SUBJECT: Engineering Review Comment
Mountain View Electric Association Inc. (MVEA)

Project Name: Falcon Ranchettes Filing No. 2

Project Number: VR239

Description: A replat of Lots 1 & 2 located west of Meridian Rd. and north of Owl Pl. in Township 13S, Range 65W, Section 01.

MERIDIAN PARK DRIVE - PUBLIC 60' R.O.W. 25 MPH DESIGN SPEED (LOCAL) SCALE: 1"=30'

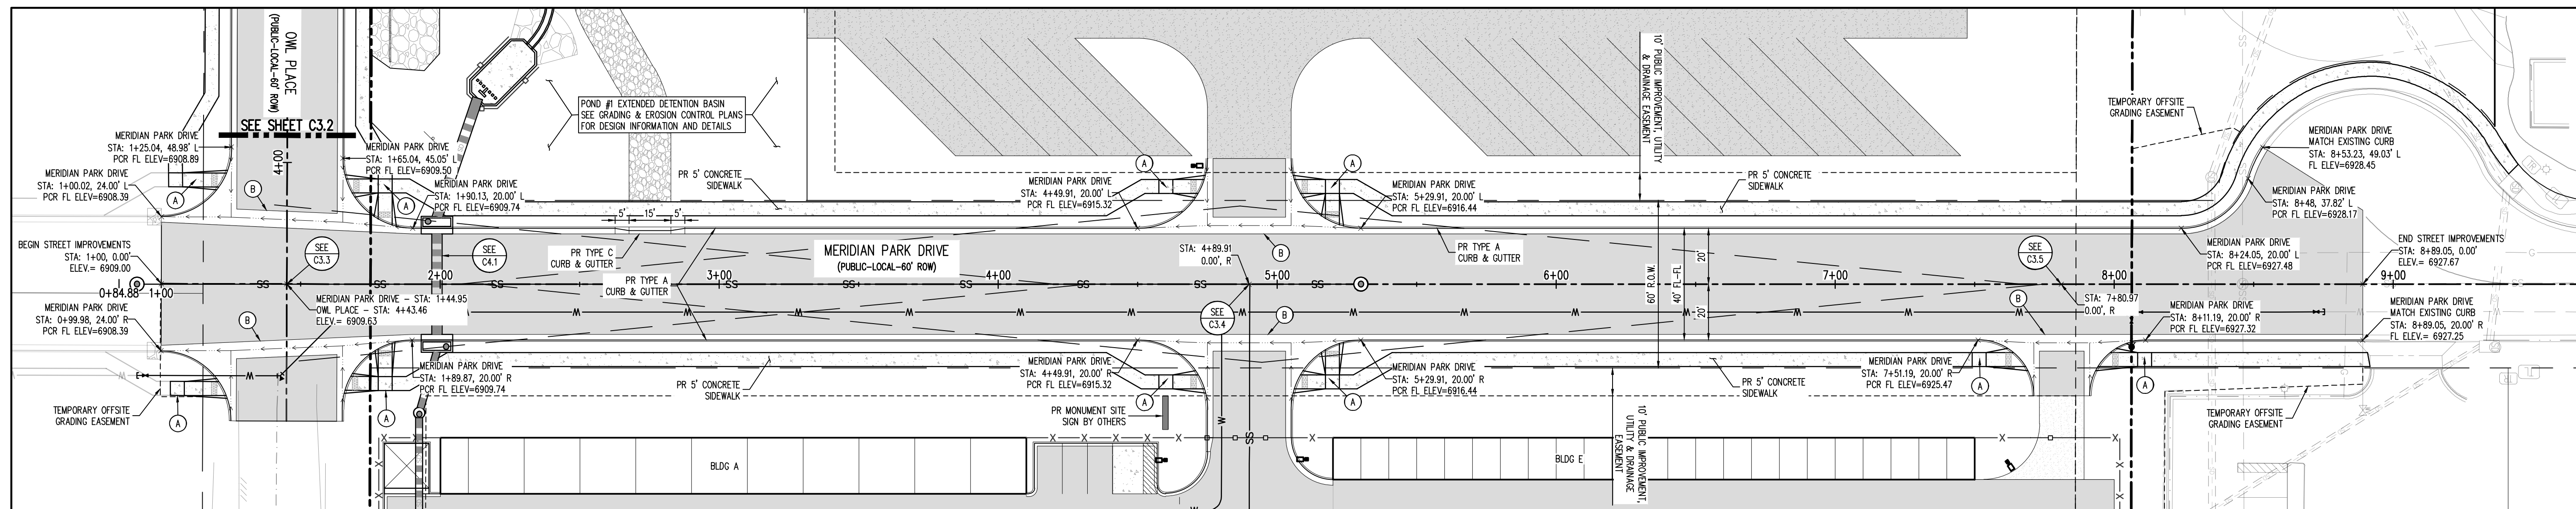
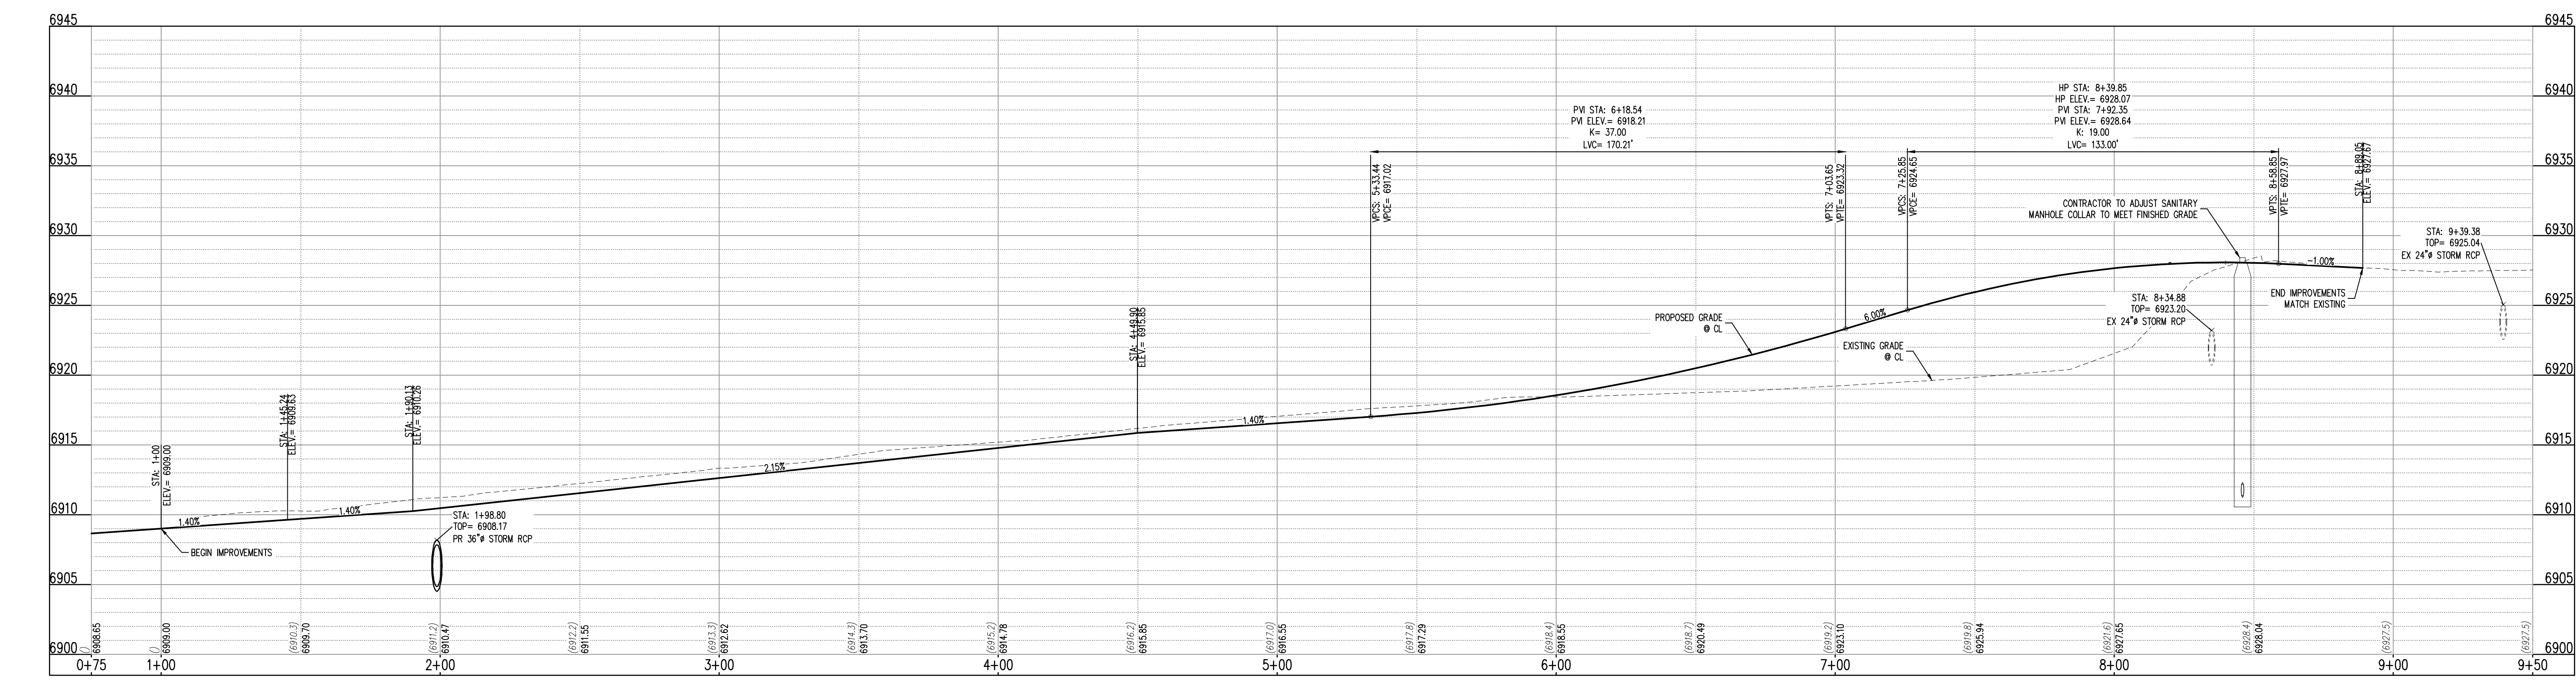
MVEA has facilities within the proposed Meridian Park Dr. and requests a twenty (20) foot utility easement on the East and West sides of the proposed road. MVEA also requests the platting of MVEA's existing facilities with easements on the plat. Additional easements may apply.
